R/141/15/PL

2 Hazel Lodge
Budlow Garden
Buxington.

I understand that planning permission has been applied for by Mrs. & Mrs. Martin of 8 Thirt House, Budlow Garden, Buxington to have the railings of their balcony at that address replaced by glass and mild steel structure.

Drawing No:	15/05/2015	Date:	15th MAY 2015
Description:	BALCONY BALUSTRADE	Finish:	GALVANISED, PPC.
Project:	MR MARTIN

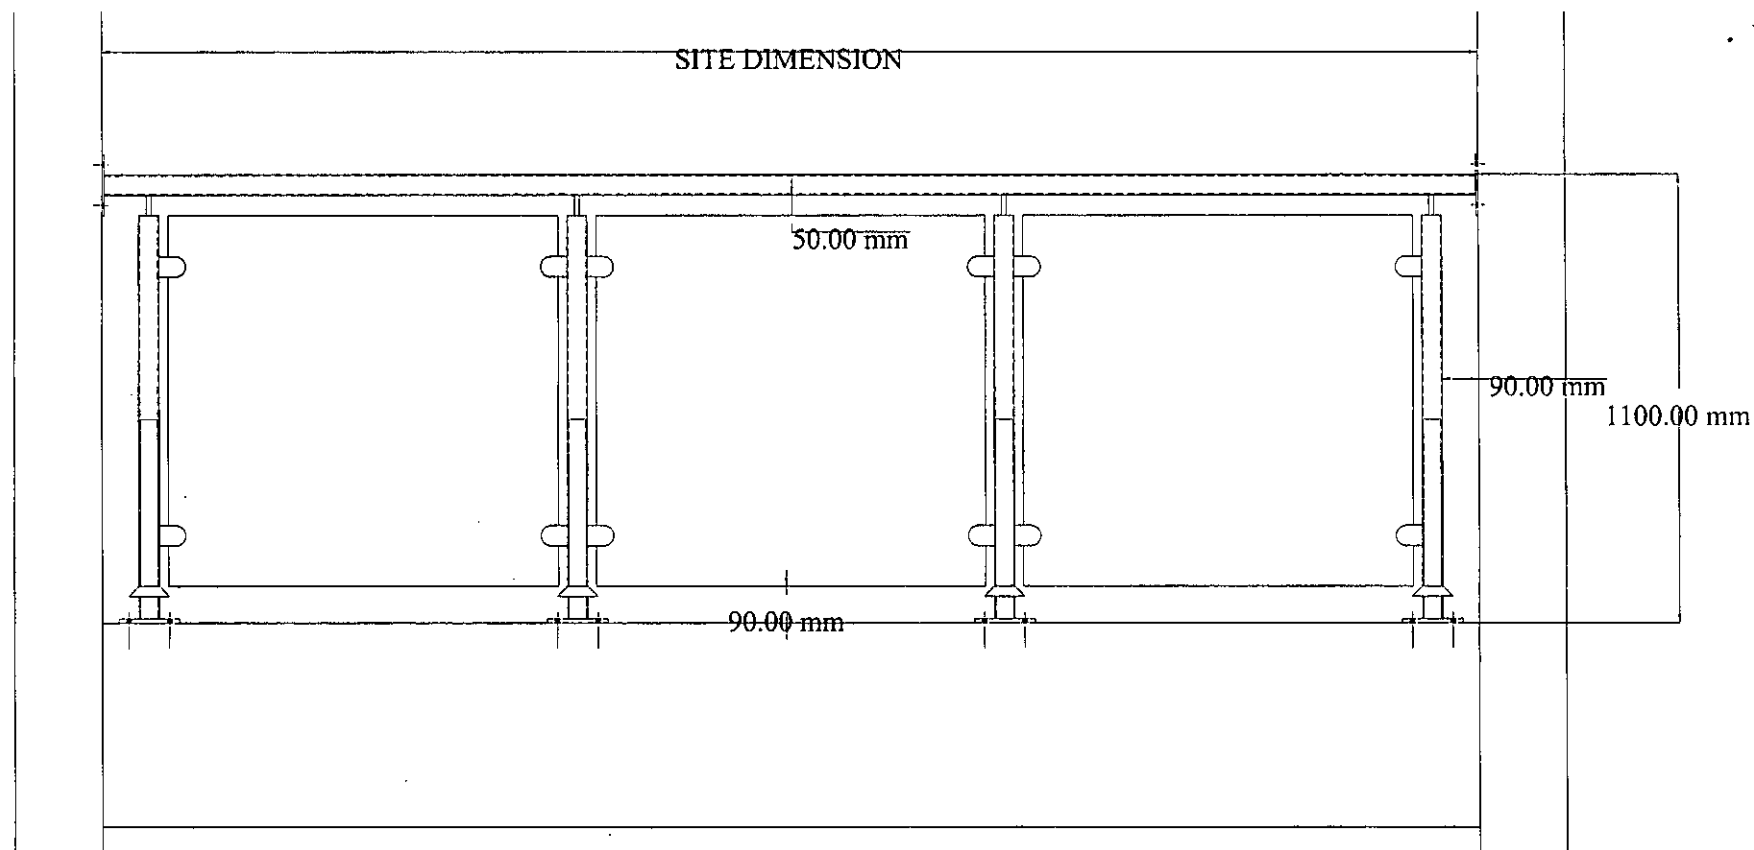
I am against this application on the grounds that the glass structure would look grossly out of place amongst balconies of mild steel and painted white. Well main-
tained the balconies look right and very nice all round this development.
